**Our Case Number:** ACP-323849-25

**An  
Coimisiún  
Pleanála**

**Re:** The proposed development is for a mixed use development that seeks the regeneration and adaptive reuse of a strategic brownfield site, as part of the Limerick City and County Council 'World Class Waterfront revitalisation and transformation project' 'Cleaves Riverside Quarter' in the townland of Farranshone More in Limerick City.

An Observation on Cleeves Riverside Quarter, Limerick.

drawing Shipyard & NCR Boundary Elevations - Proposed

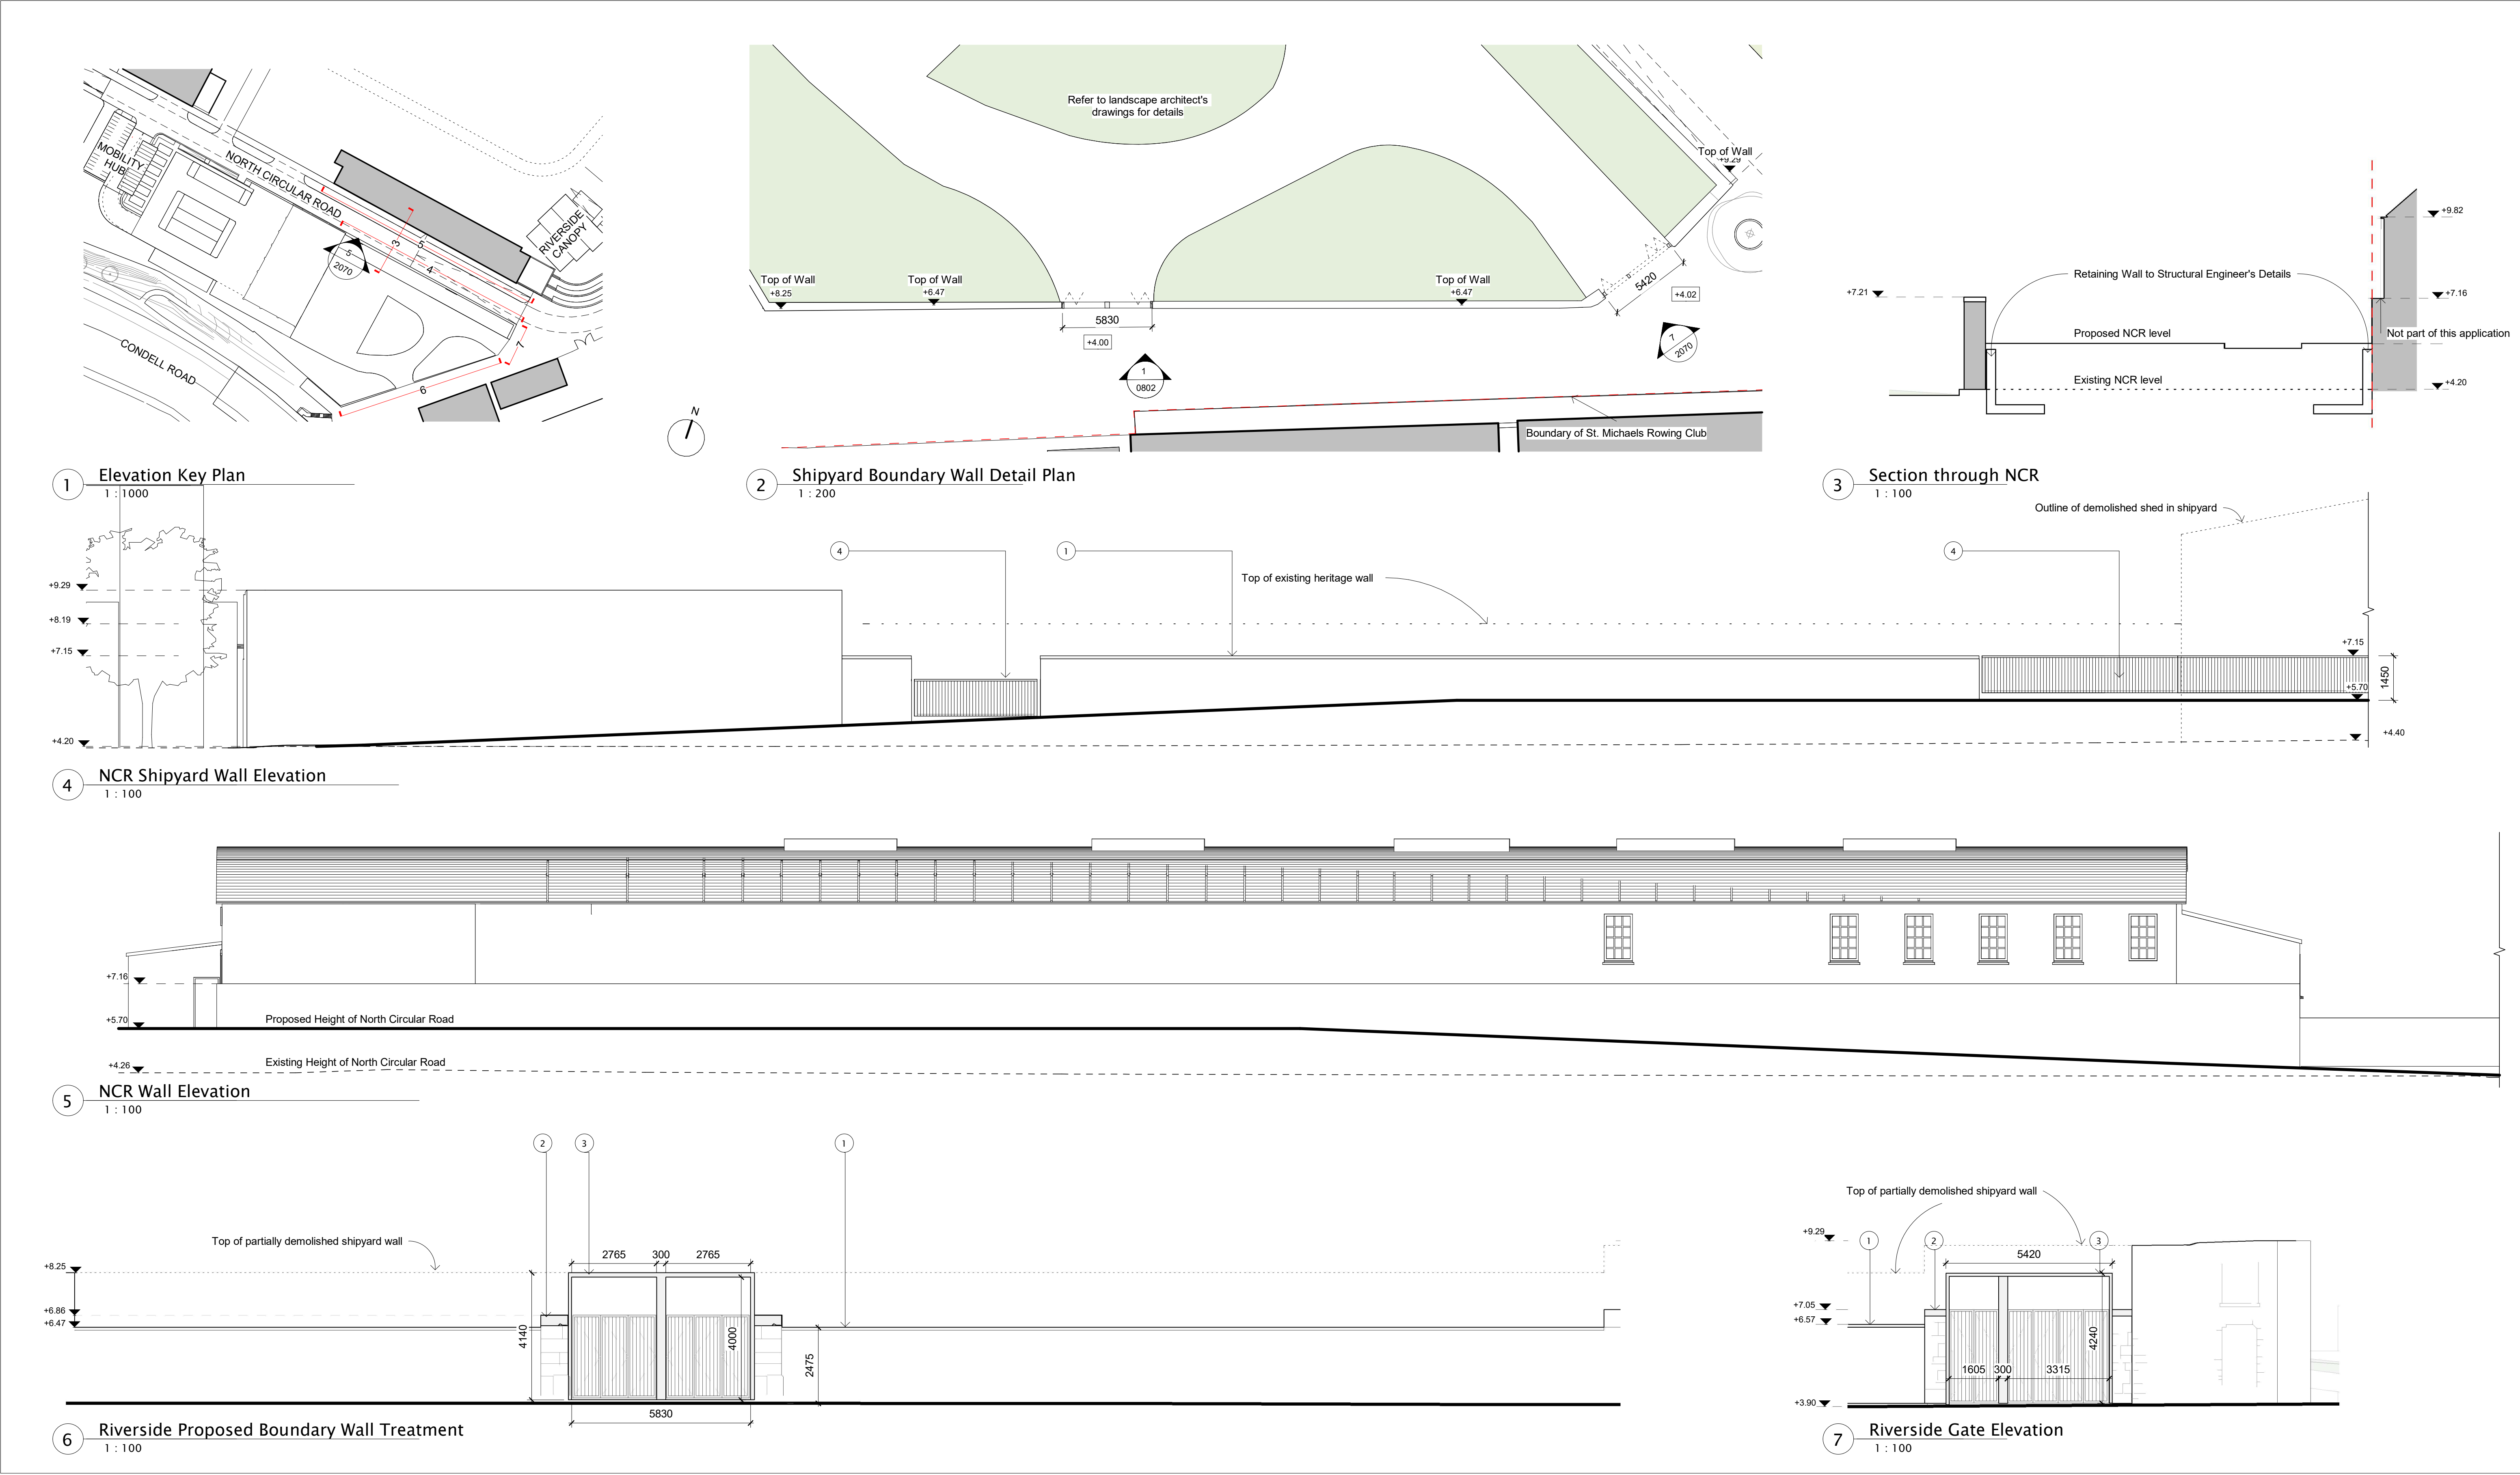
The EIAR states that the fern was 'confirmed to be present' on the southern and eastern boundary walls in multiple pockets' - these are the street-facing walls on O'Callaghan Strand and the North Circular Road.

Unfortunately, this is its only record of the fern on the site, and from this it appears that the site was not thoroughly examined. On a site visit on 16<sup>th</sup> June 2022 by members of the Limerick IWT it was also observed growing on the south-facing wall of the flaxmill building, in the joints between the blocks (see attached photo). There were numerous colonies of the plant. In addition it was noted to be present on the internal side of the O'Callaghan Strand wall.

The development proposes to lower the boundary wall on O'Callaghan Strand to 450mm, and this will seriously deplete, if not entirely remove, the Maidenhair Fern from the O'Callaghan Strand wall. It is also proposed to stabilise the walls on the North Circular Road, following works to facilitate raising the level of the road.

We would recommend that these old walls should not be repointed (unless absolutely necessary for safety reasons) to avoid removing any of the plants which have naturally colonised them.

It is our opinion that the value of these stone walls is undervalued in the EIAR. We believe that such value should be increased with a greater emphasis on mitigations for this habitat, and the Maidenhair Fern.
